City of Albuquerque Stormwater Construction Site Inspection Report

Project Name and Location	Murphy Express 1358 Wyoming NE		
Site Contact Name & Agency	Shawn Cook JMD Construction	ESC File No. NPDES ID No.	J20E037
Date of Inspection	10-23-18	Start/End Time	11:50/12:00
COA Inspector Name	Curtis Cherne, Stormwater Quality		
Describe Present Phase of Construction	Constructing bldg and canopy and utilities		
Type of Inspection:	<input type="checkbox"/> Regular <input type="checkbox"/> During storm event <input type="checkbox"/> Post-storm event (> 0.25 inch) <input type="checkbox"/> 311 / Complaint Response <input checked="" type="checkbox"/> Follow-Up

SHEET NO. **C-4.1**
 JOHN H. NOURDAD
 NEW MEXICO
 PROFESSIONAL ENGINEER
 11/15/17

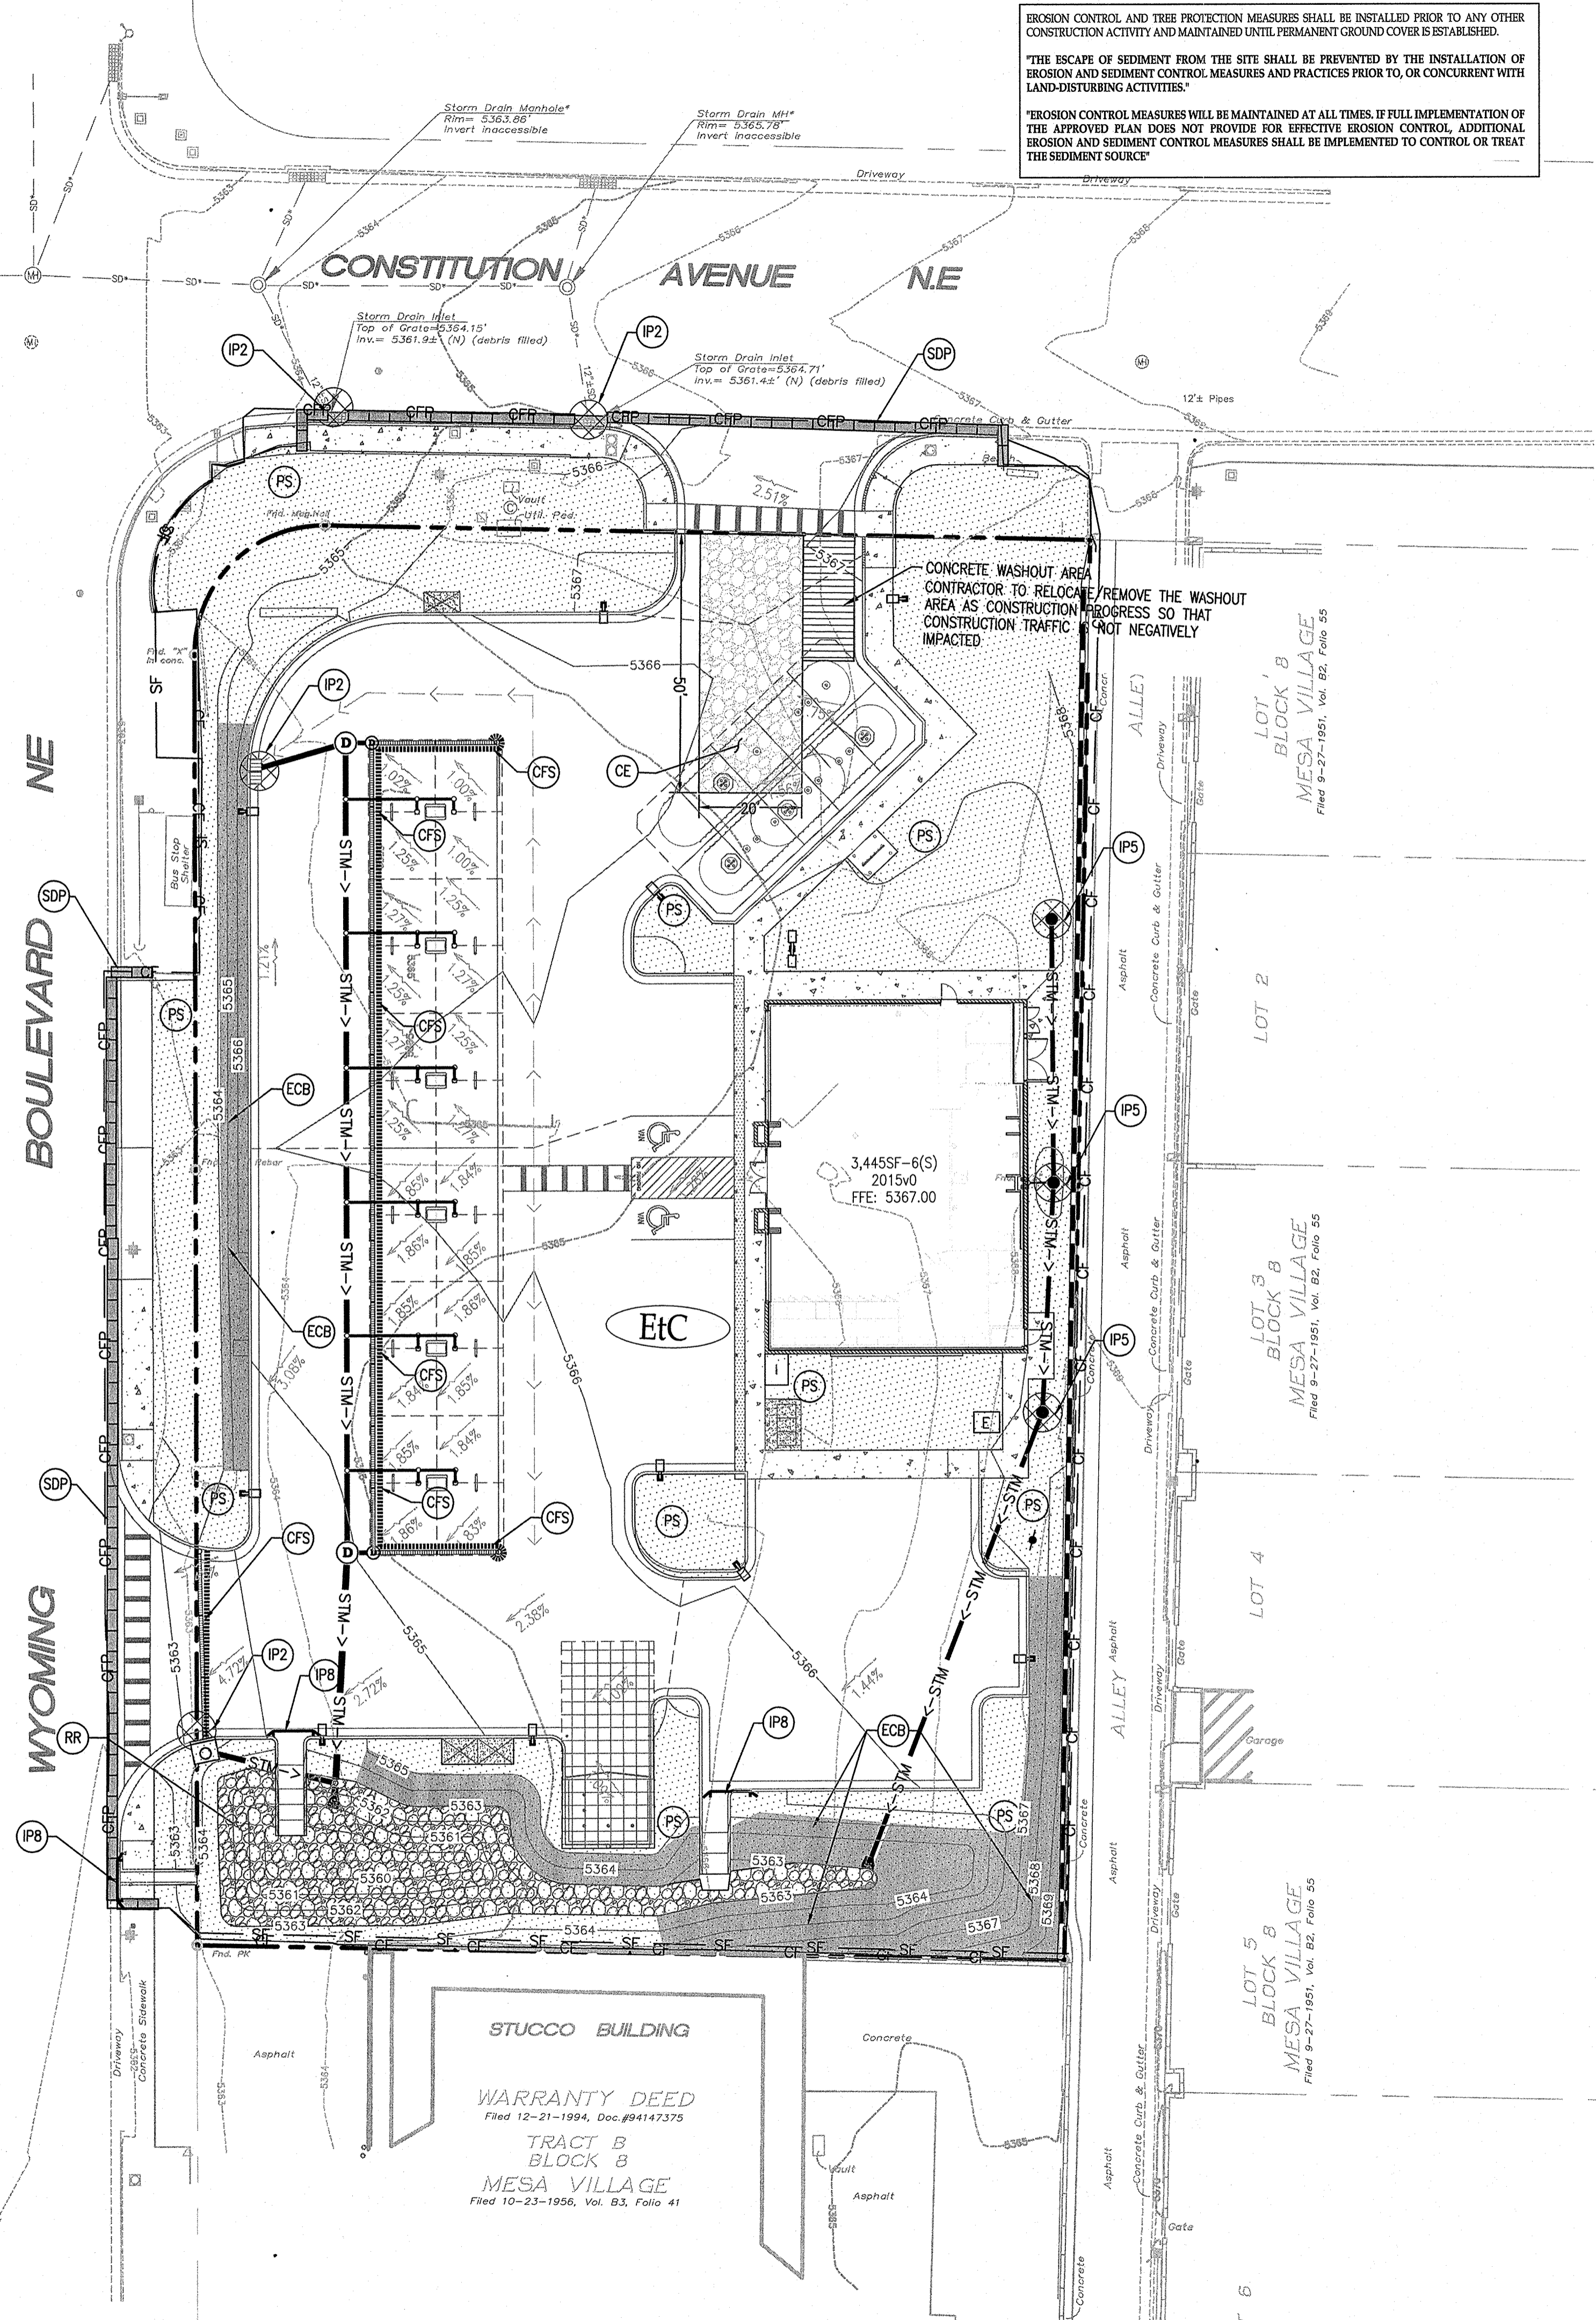
CGP	BMP / Activity	Maintenance Required? (1)	Corrective Action Required? (2)	Location and Notes
1.5	Post a Notice		✓	not posted
2.2.1	Provide and maintain Natural buffer when Waters of the US < 50 ft			
2.2.3	Sediment control along any perimeter	✓		sediment in Wyoming Blvd
2.2.3	Sediment control along any perimeter			
2.2.3	Sediment control along any perimeter			
2.2.3	Sediment control along any perimeter			
2.2.3	Sediment control along any perimeter			
2.2.3	Sediment control along any perimeter			
2.2.3	Sediment control along any perimeter			
2.2.4	Minimize sediment track-out			minor track-out, replaced track-out pad
2.2.5	Manage stockpiles
